From: Stuart Magowan [REDACTED]
Sent: 25 September 2020 11:36
To: Anita Gardner <Anita.Gardner@arun.gov.uk>; Paul Cann <Paul.Cann@arun.gov.uk>
[REDACTED]

Subject: RE: F/21/20/DOC Wicks Farm

The following link will allow a download of the drawings as noted on the attached drawing issue register together with the updated Reservoir Calculations and Management and Maintenance Plan. For ease of reference I have noted our responses in green below to the latest comments.

CLIENT	DPS Limited			
PROJECT	Wicks Farm Polytunnel Ford			
TITLE	Sections			
DRAWN	P Reynolds	DATE	Aug 2020	
ENGINEER	S Burgess	CHECKED	SB	
SCALE	As shown @ A1		PROJECT NO.	23314
			DWG No.	REV.
			70	A

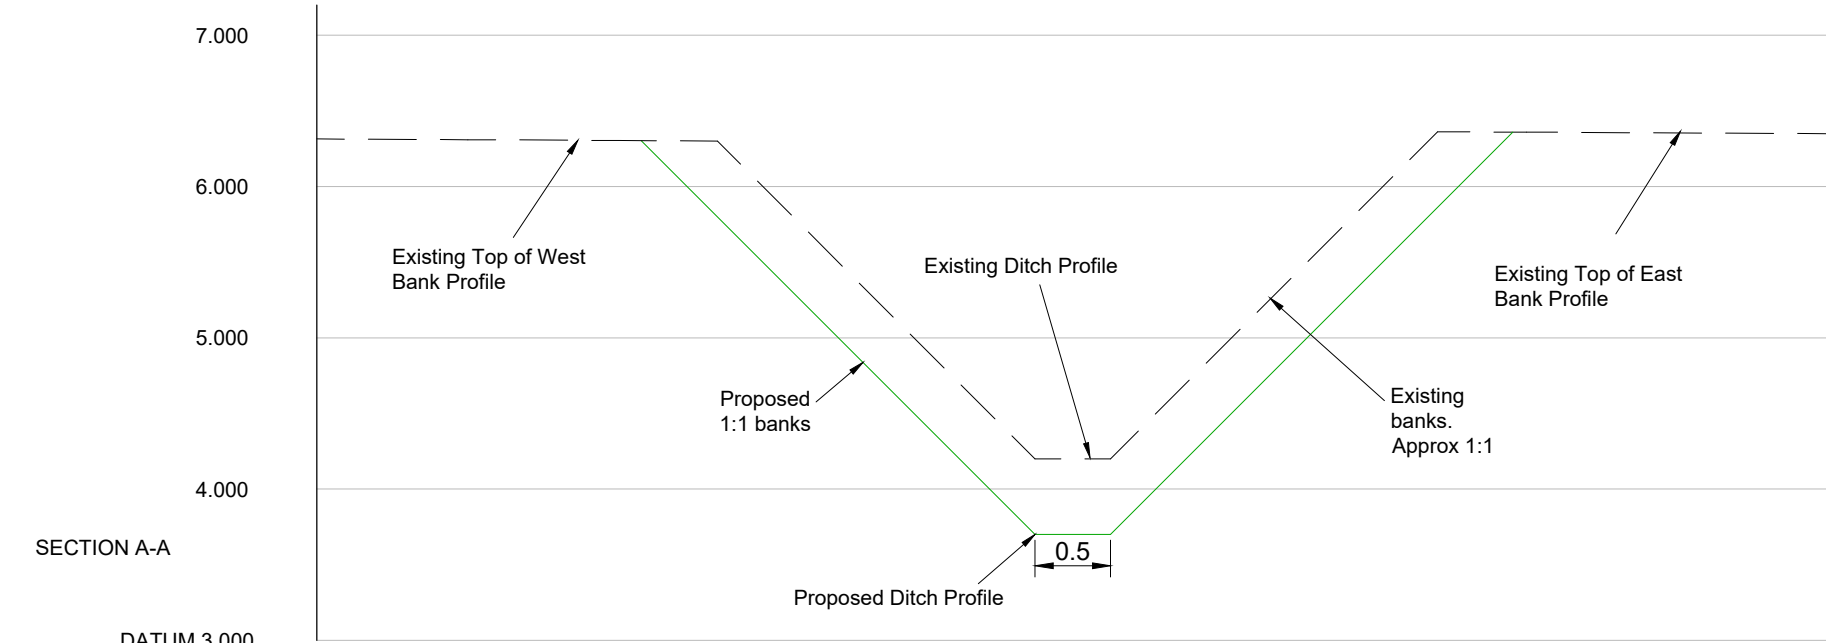
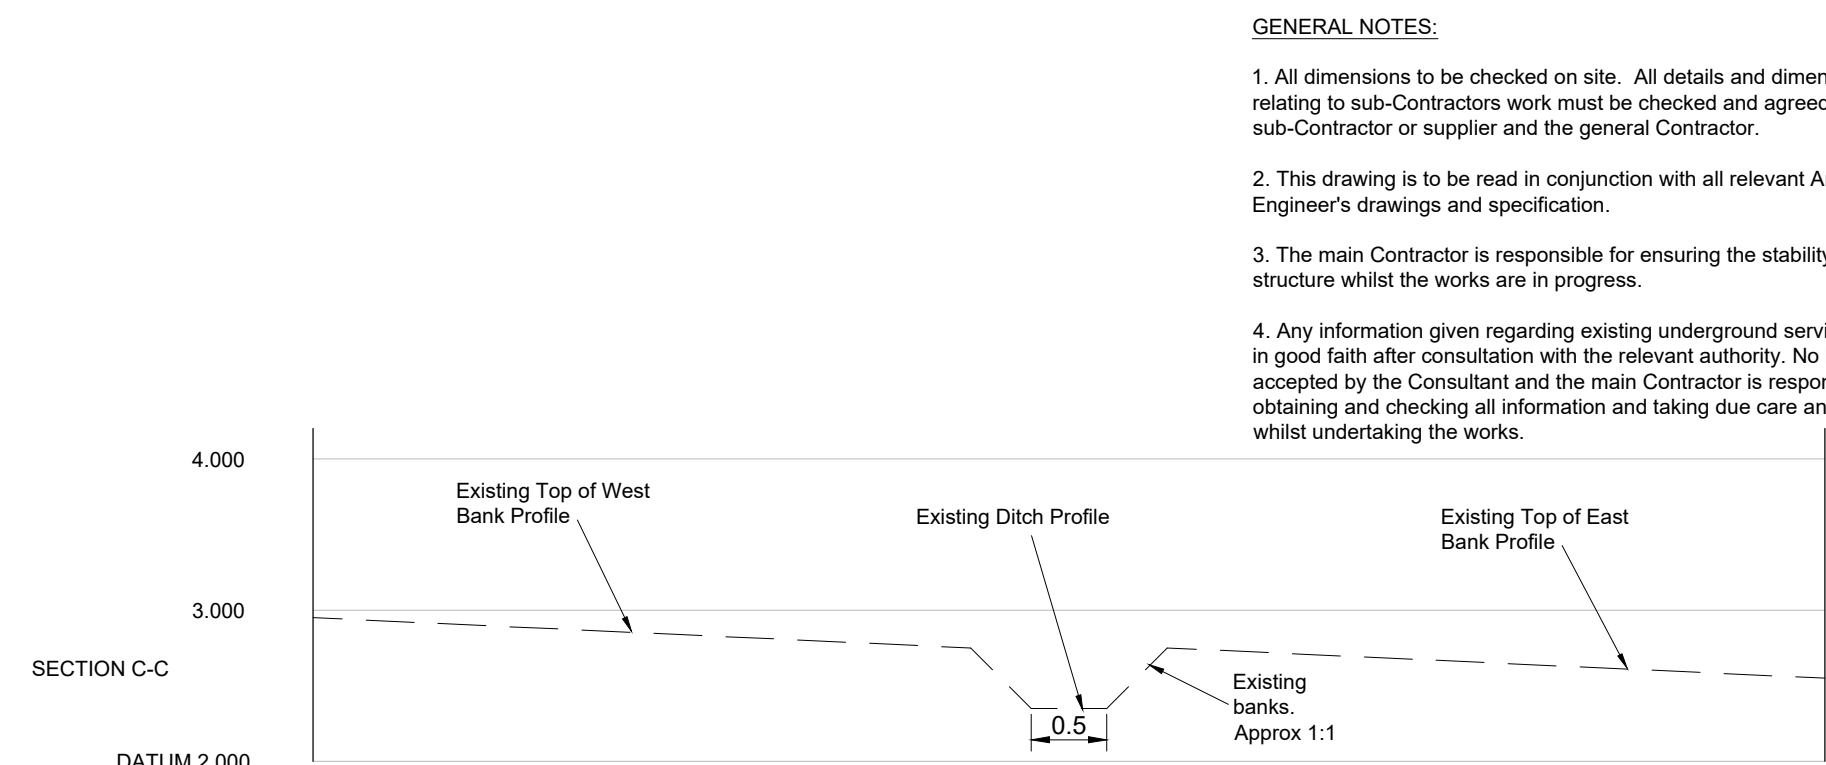
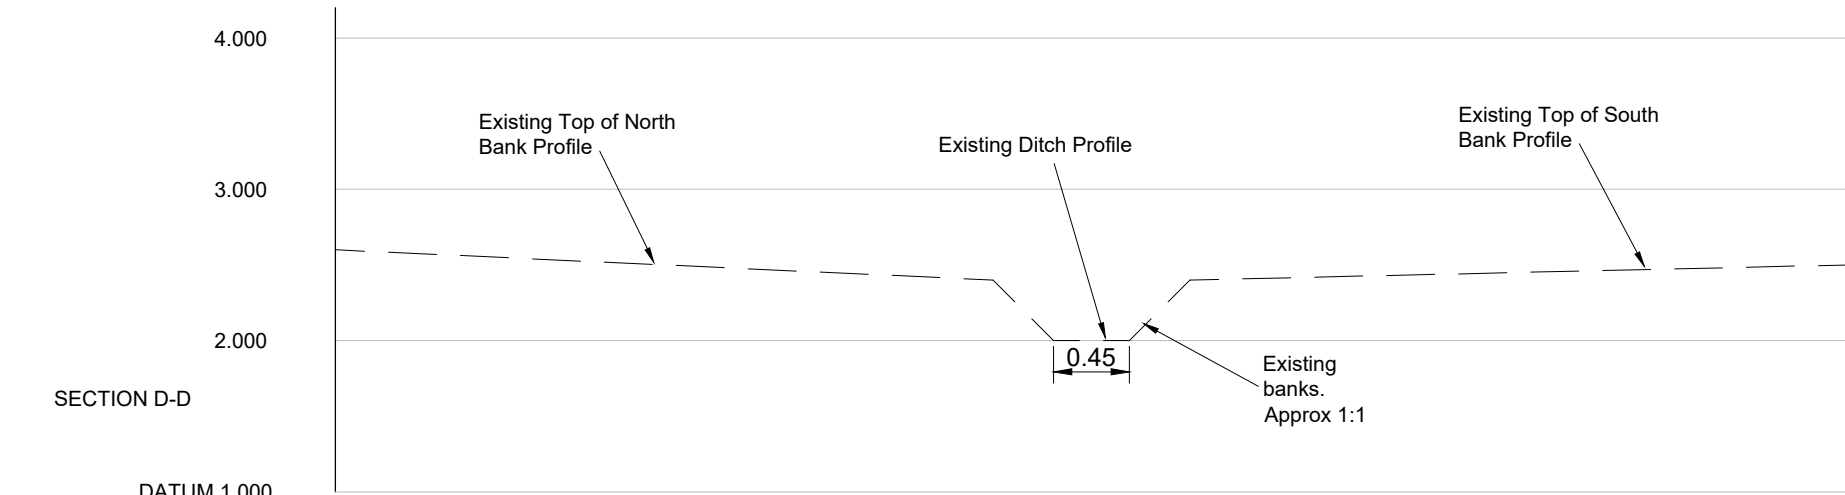
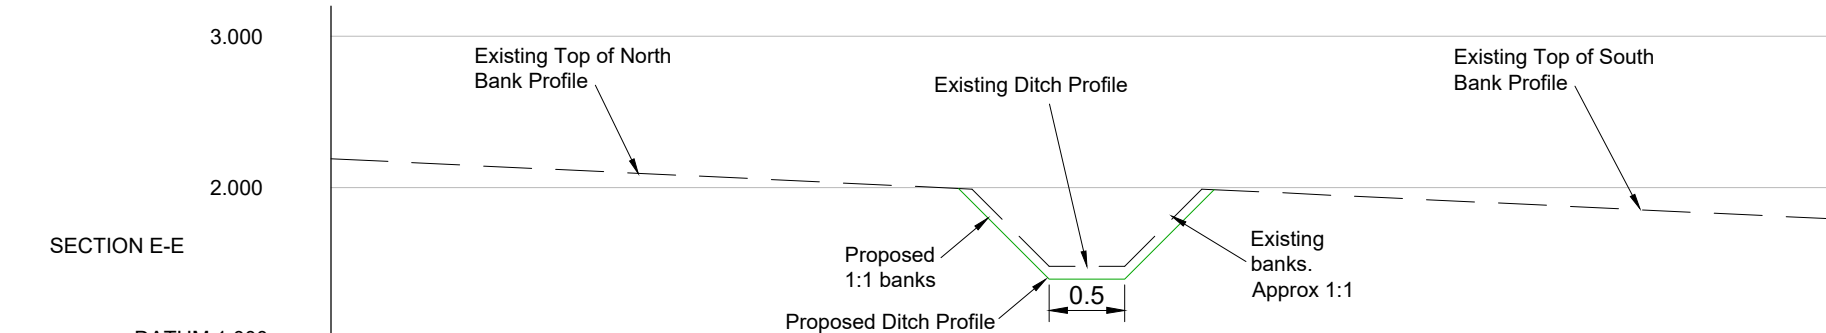
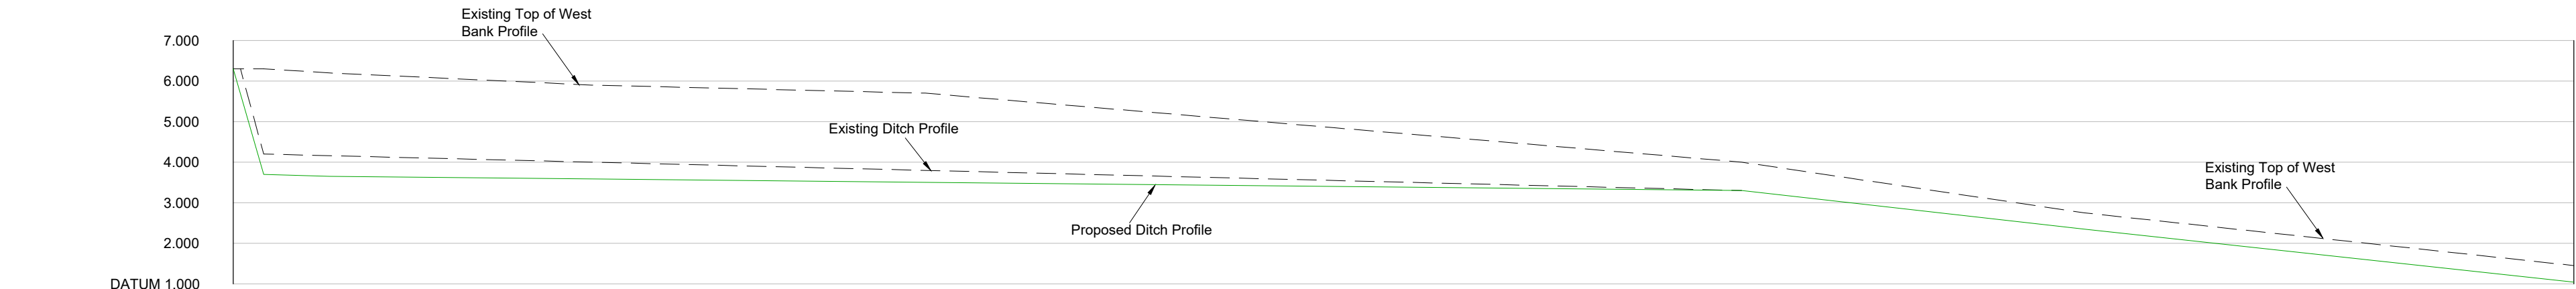
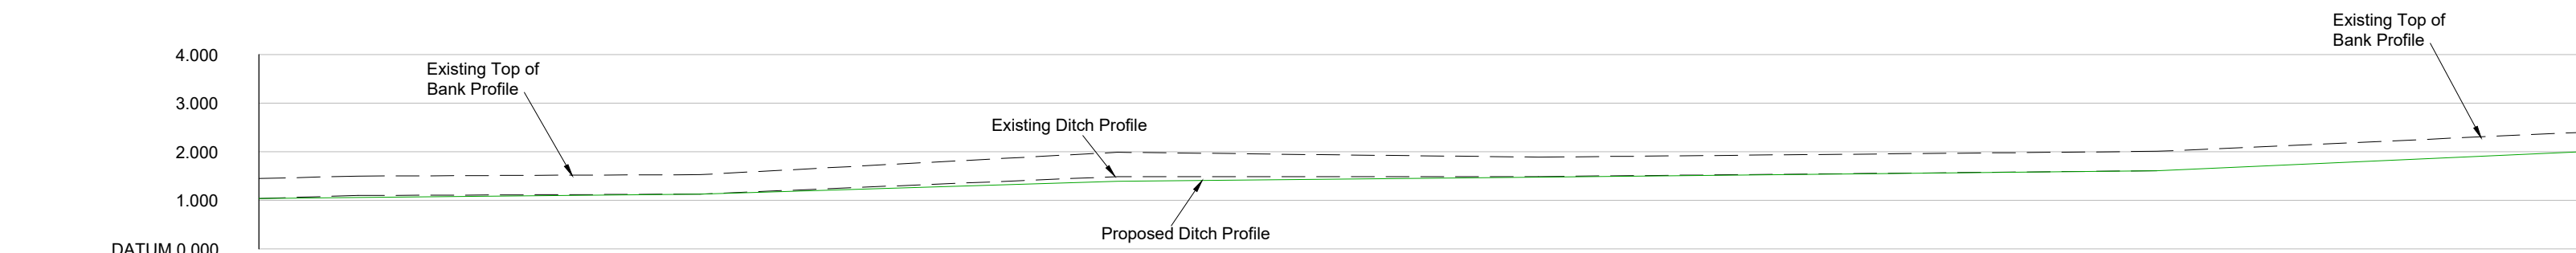
1. The northern boundary ditch in vicinity of the proposed reservoir is currently located on the other side of the network rail fence and not within the redline boundary. As previously suggested a ditch

will be required within the red line boundary and running parallel to the network rail ditch. Please adjust drawings and provide a typical profile cross section. Land drainage consent is also required for the new ditch and headwall outlet. There is an existing ditch on site at the northern boundary and a further ditch the other side of the Network Rail fence, the existing ditch is noted to be cleared of debris, vegetation and silt and regraded where required. This is indicated on drawings 21E, 22E and 24E. The comments on Land Drainage Consent are noted but are not a reason to refuse discharge of condition as they are covered by separate legislation. My last visit to site indicated that there was no obvious ditch in vicinity of the reservoir, apart from the one on the other side of the Network Rail fence, however, provided the ditch is installed as per the drawings then this is not an issue. On the cross sections ie. D-D and E-E, clearly indicate the ditch base width and the gradient of the side slopes. Land drainage consent is an integral part of the outstanding conditions ie. no.8, and in this instance, I am prepared to allow the consent to be just made for the headwall structure/discharge -- please therefore submit as necessary. Noted. The ditch base and bank gradients have been added to all sections A-A to E-E. See Drawing 70.

11. **Provide longitudinal section showing existing and proposed bed levels.** This is an existing ditch, we have provided the existing levels on the submitted drawings, long section is included in the above link on drawing 70. Ok. Noted.
